Our ref: HMS ID 14181

Advice on Environmental Impact Statement – State Significant Development

Proposal: Project Mars Data Centre

Major Project reference: SSD-82052708

Figure 4: Proposed works (General Arrangement Site Plan supplied by Goodman) with the location of Mars Rd PAD 1 shown in blue

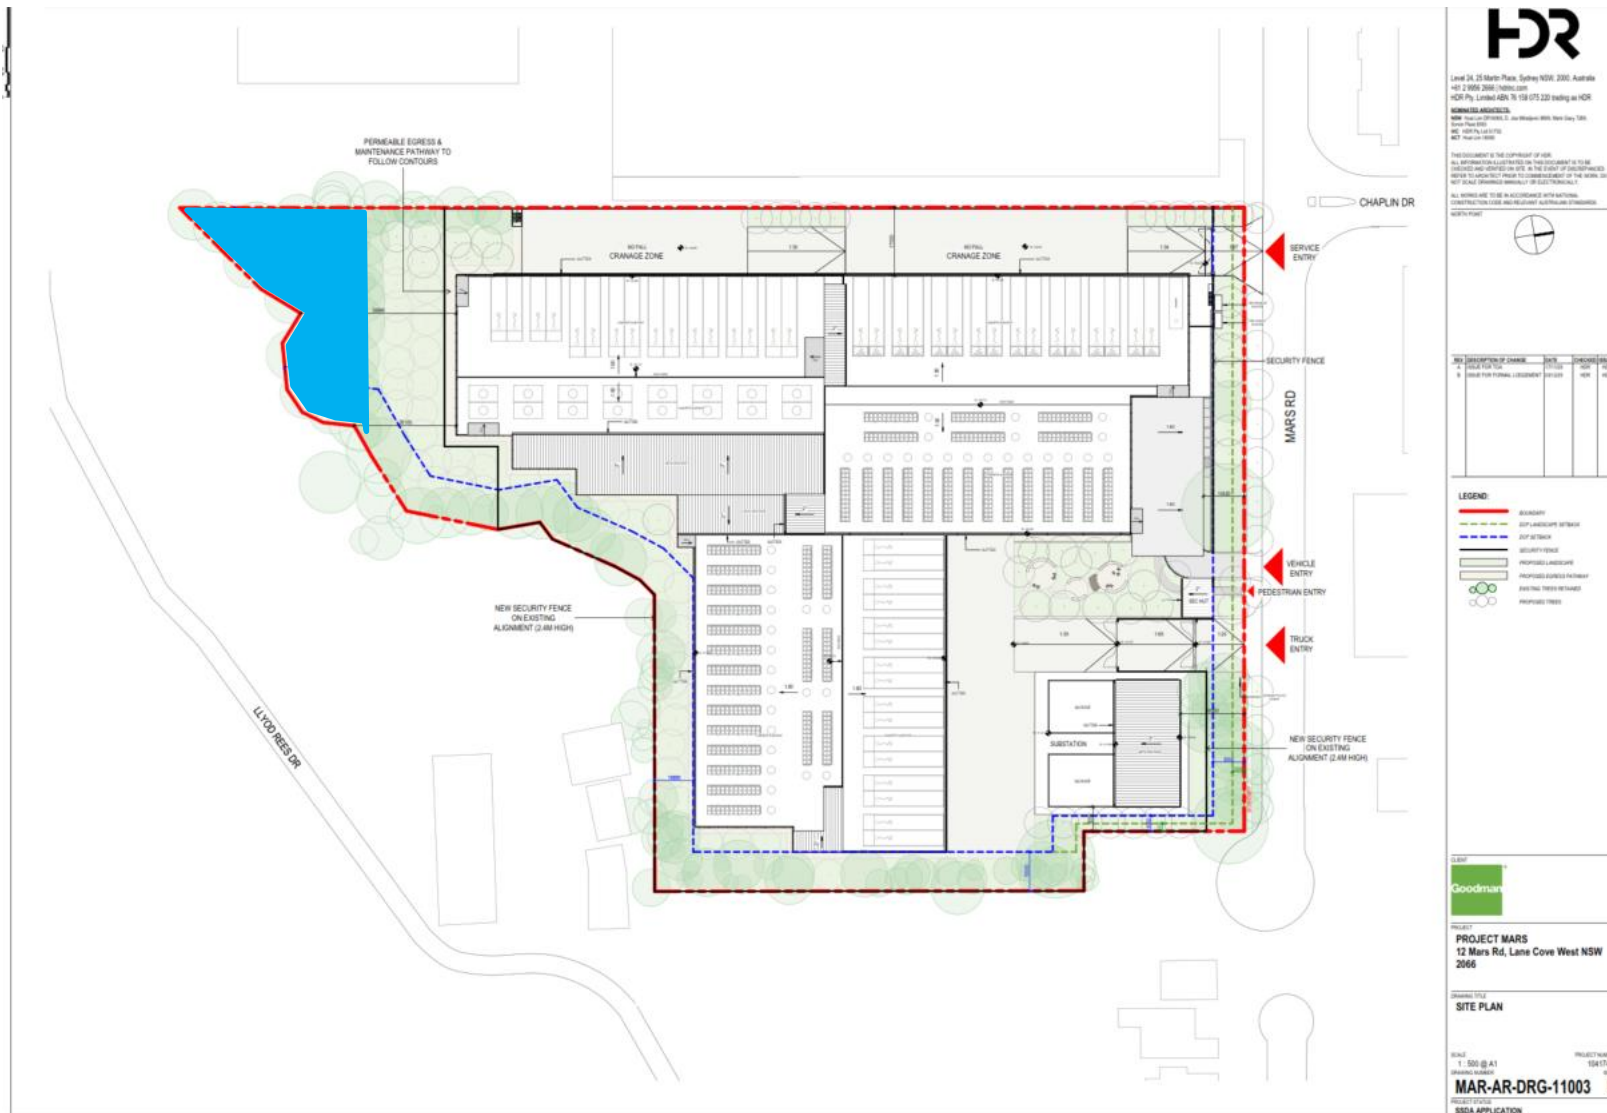
1. While *Mars Rd PAD 1* is not proposed to be impacted by the current works, the PAD should be registered on the Aboriginal Heritage Information Management System (AHIMS) to ensure appropriate future consideration and management should works be proposed within or adjacent to the PAD.
